Request for Secretary's Environmental Assessment Requirements (SEARs) for ASN Co Building, 1-3 Hickson Road, The Rocks (SSD 8967)

Reference is made to your correspondence received on 12 December 2017 requesting SEARs input from the Heritage Council of NSW (the Heritage Council) for State Significant Development (SSD) 8967 which proposes works to Bays 4 and 5 of the ASN Co Building. The works include the installation of an external ramp, removal of concrete floors and reinstallation of timber flooring (using salvaged timber where possible), and upgraded amenities and fire, electrical, hydraulic and fire safety services to support a future commercial use.

External Access Ramp Details

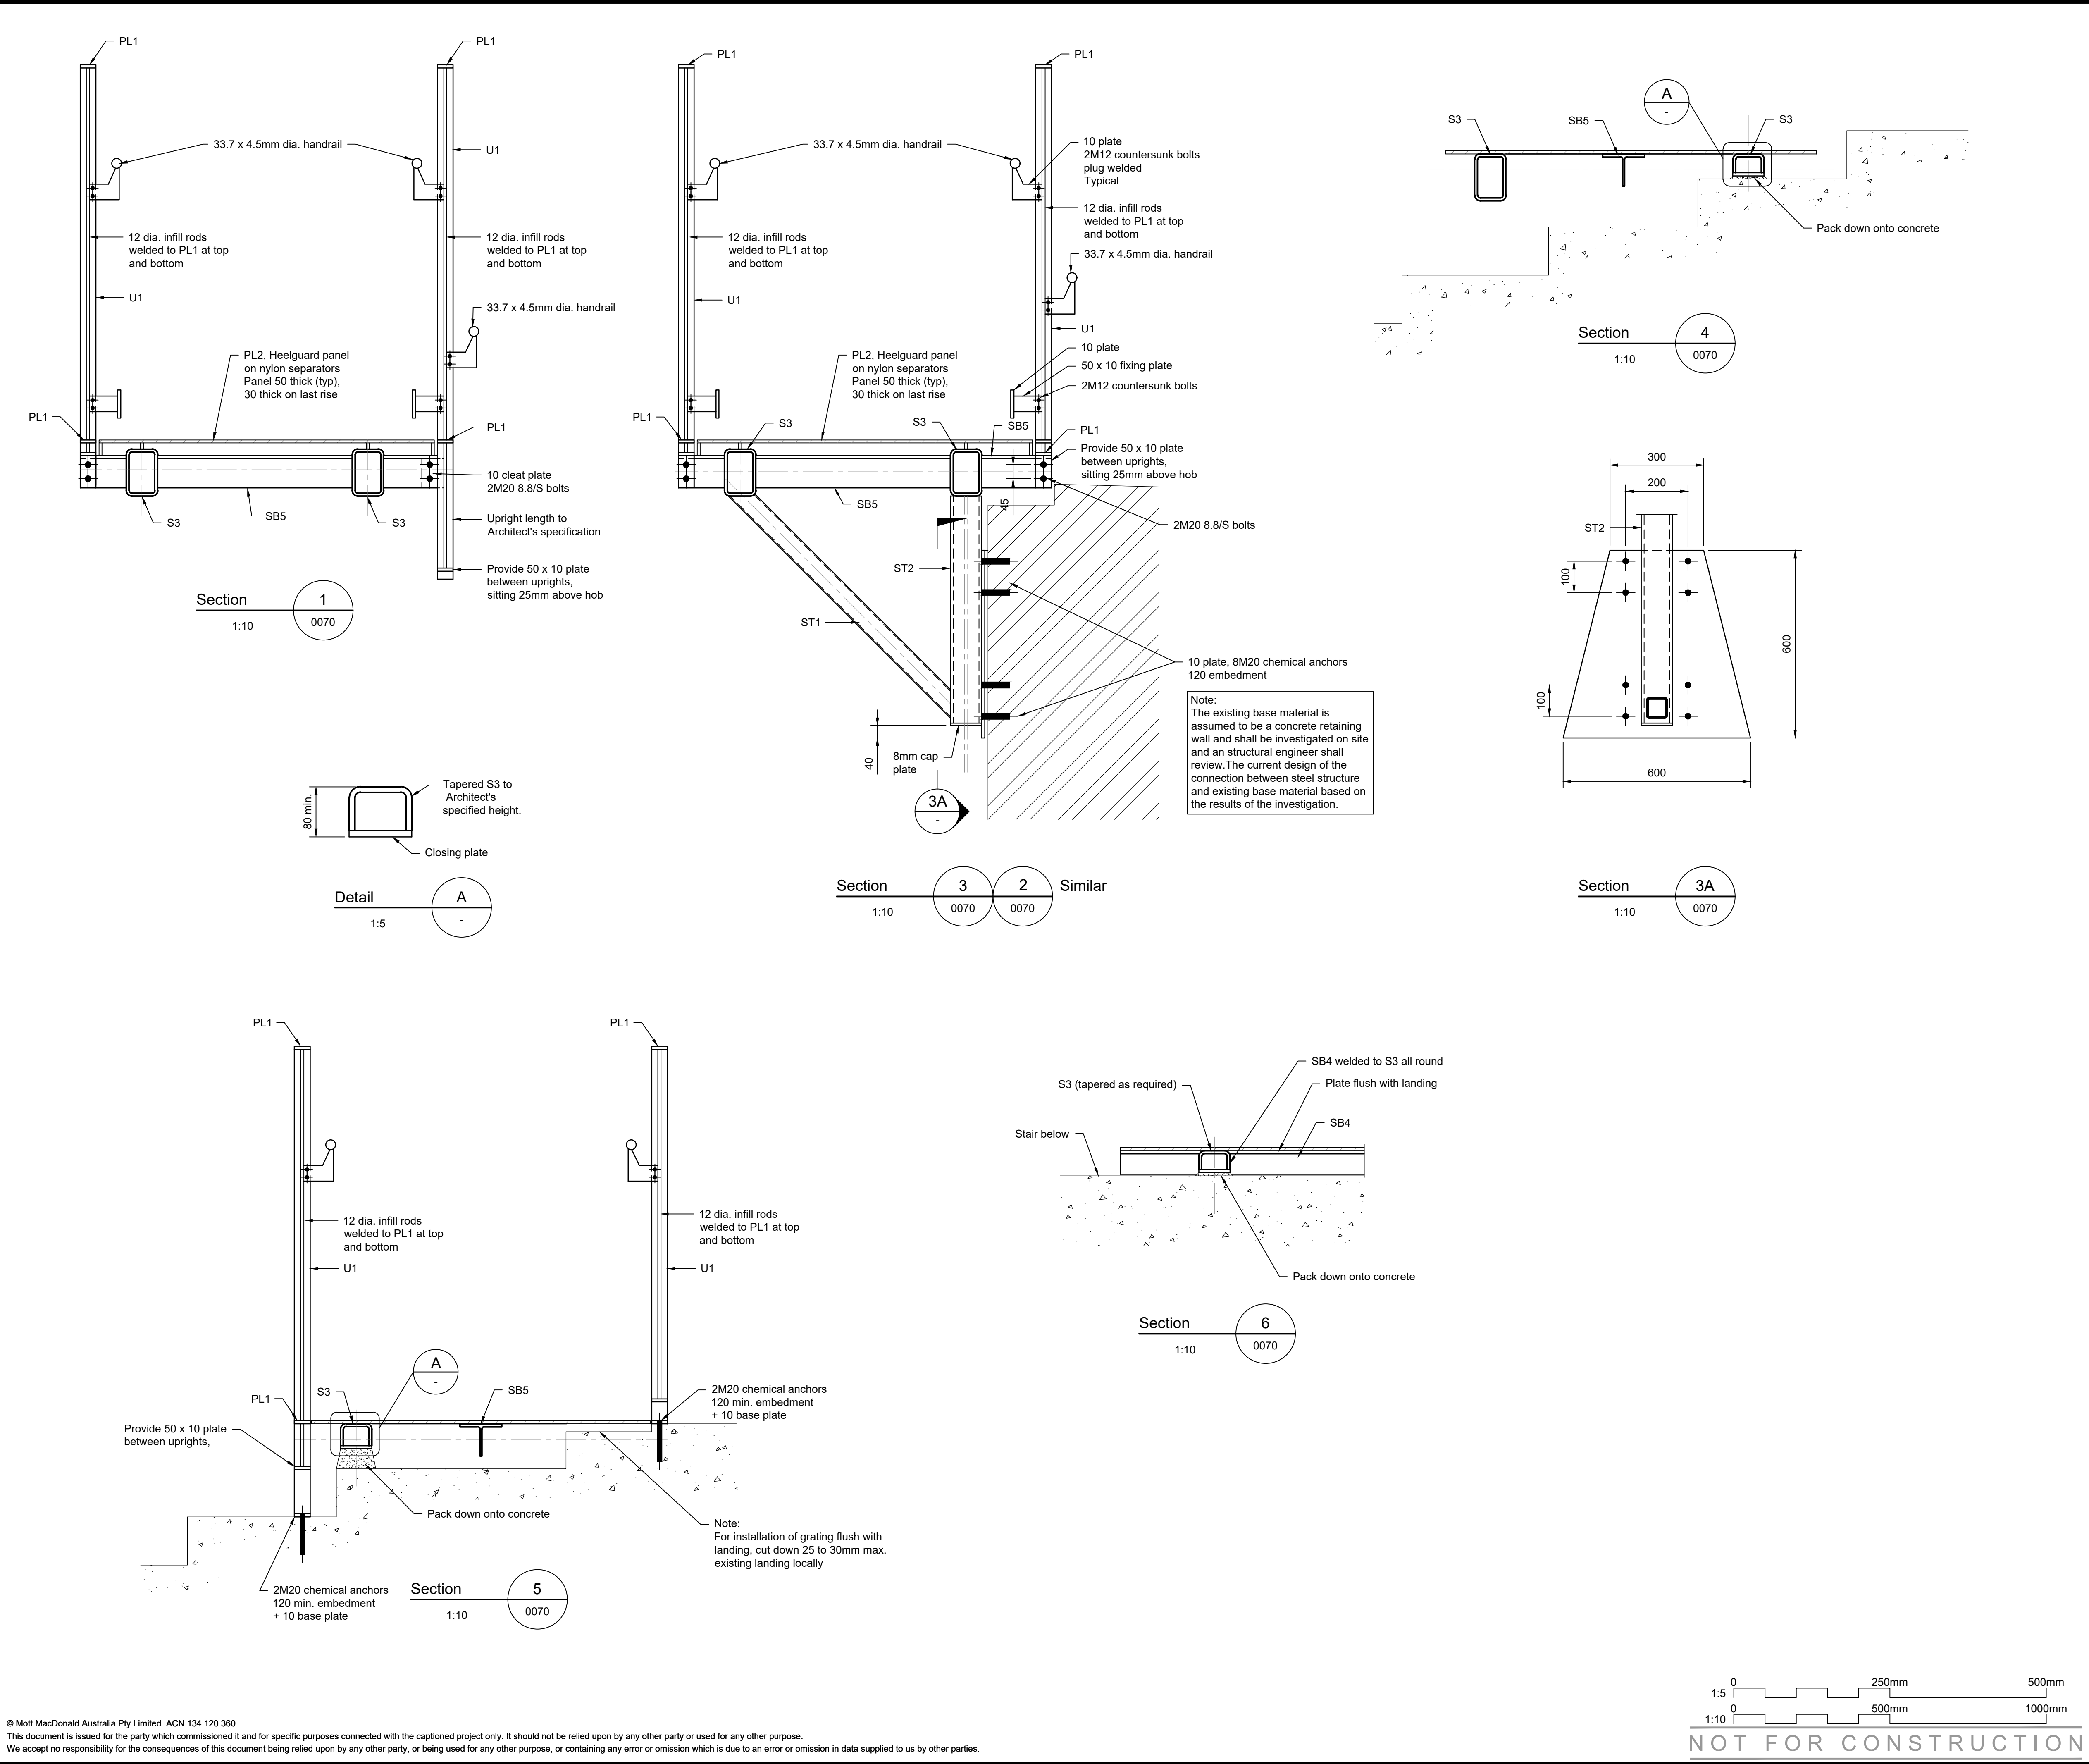
3. *The proposed design of the balustrade for the new access ramp along Hickson Road is not approved in its current form. Alternative design options shall be explored to minimise impact, and amended design submitted for the Delegate's approval.*

It is therefore, requested that the applicant be required to demonstrate how the design of the balustrade of the access ramp proposed as part of SSD 8967 has been refined in accordance with the above condition.
